3594

LAND OFF NABBS LANE, SLAITHWAITE

DRY STONE – STYLE WALL | SOUTH

Proposed South Elevation - 1:100

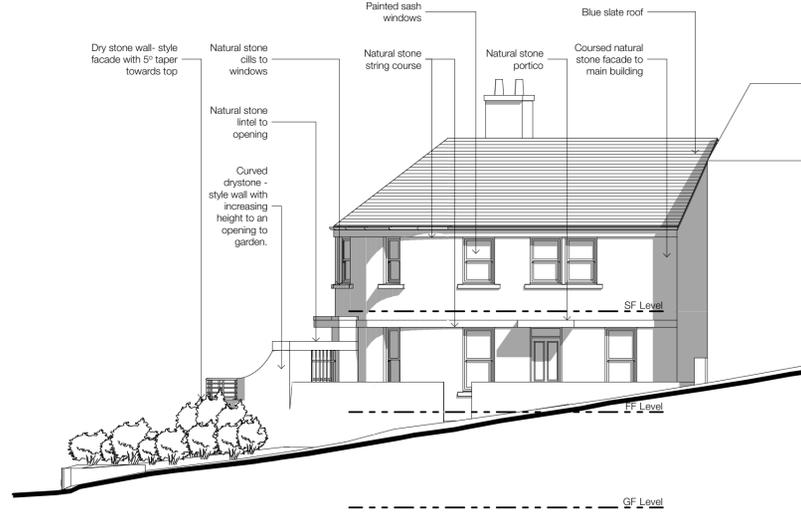
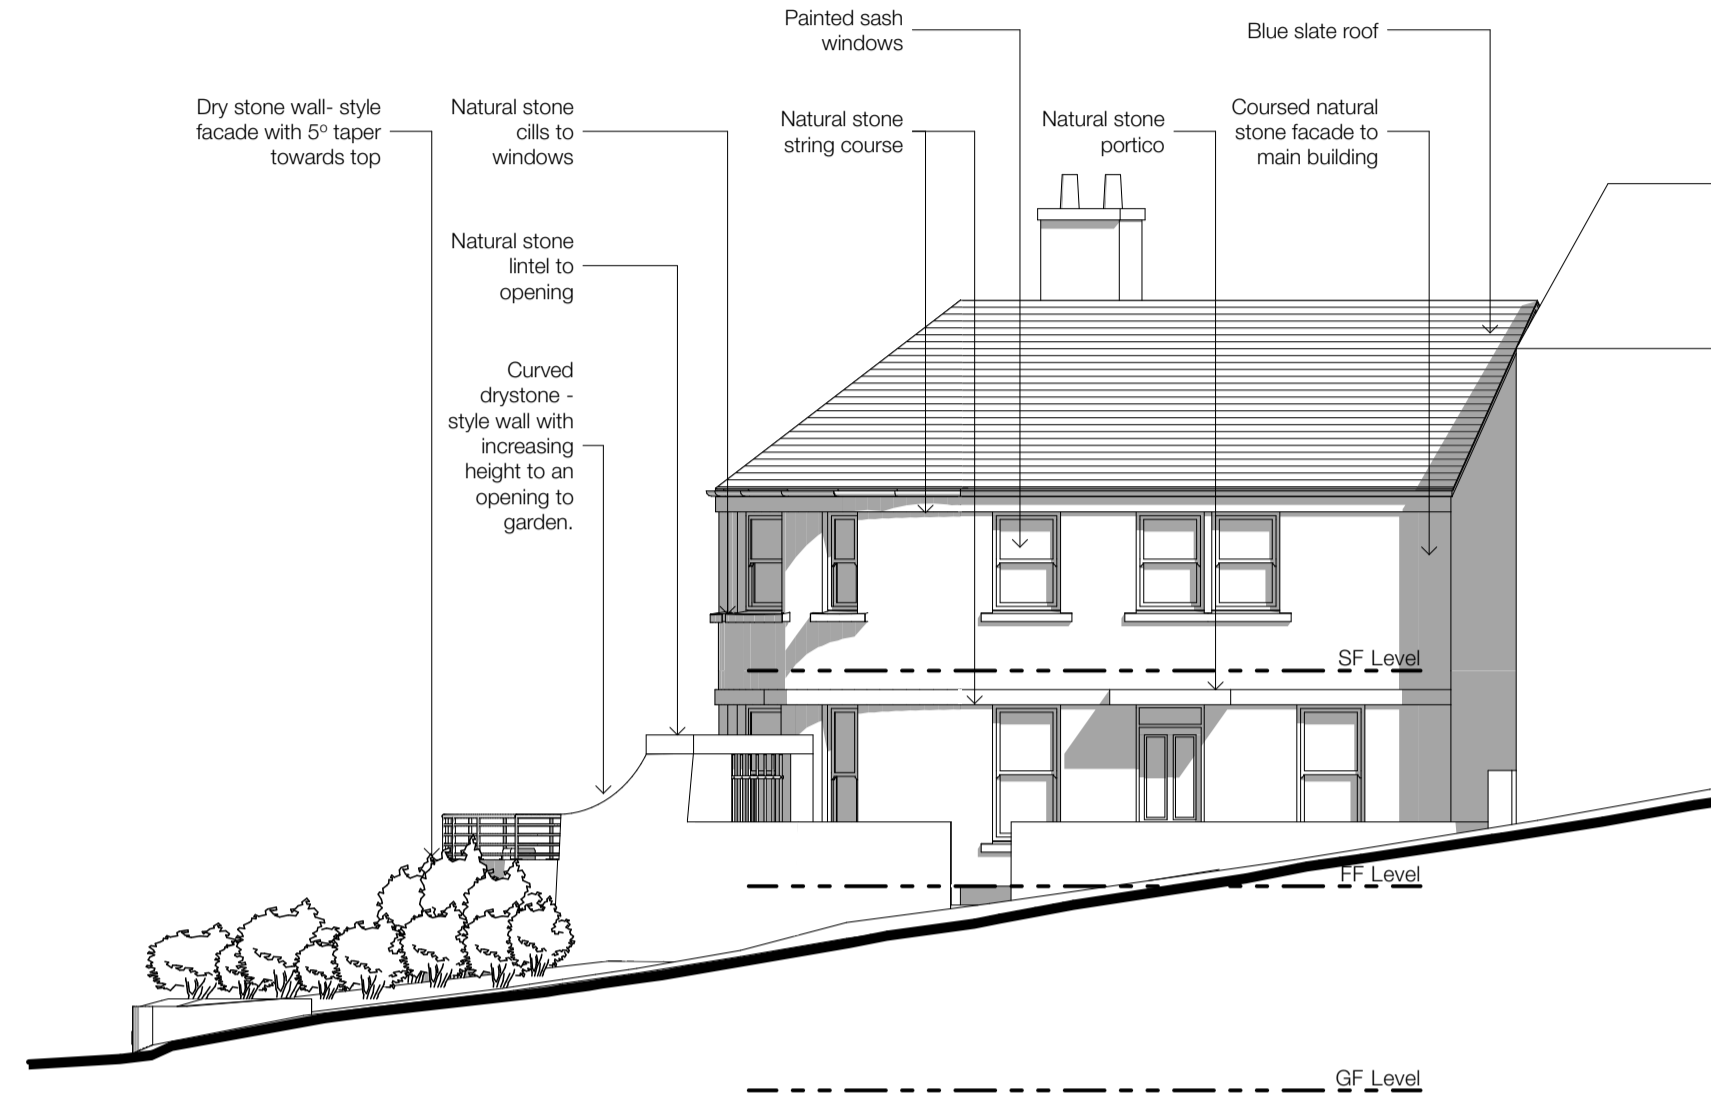
The revised scheme reduces the visual impact of the dry stone- style wall, by lowering it's height by 500mm directly addressing the concerns highlighted in the Officer's report:

' The single storey flat roofed element to the front of the site is considered to create a feature which has an overly domineering and has a significant impact...'

As well as this, the fenestration details of the south elevation have been amended in line with the comments of the Planning Officer in a meeting with the Agent (ONE17) on 20/12/24. It was agreed that the amendments address the concerns outlined in the Officer's report:

'As a result of the ... fenestration details at the first floor level, the proposed dwelling would be out of character with the locality.'

In the revised scheme, an open metal balustrade is placed atop the wall, maintaining the necessary 1100mm height from the terrace to ensure safety. The transparent nature of the balustrade significantly reduces its visual impact compared with the wall of the original scheme.
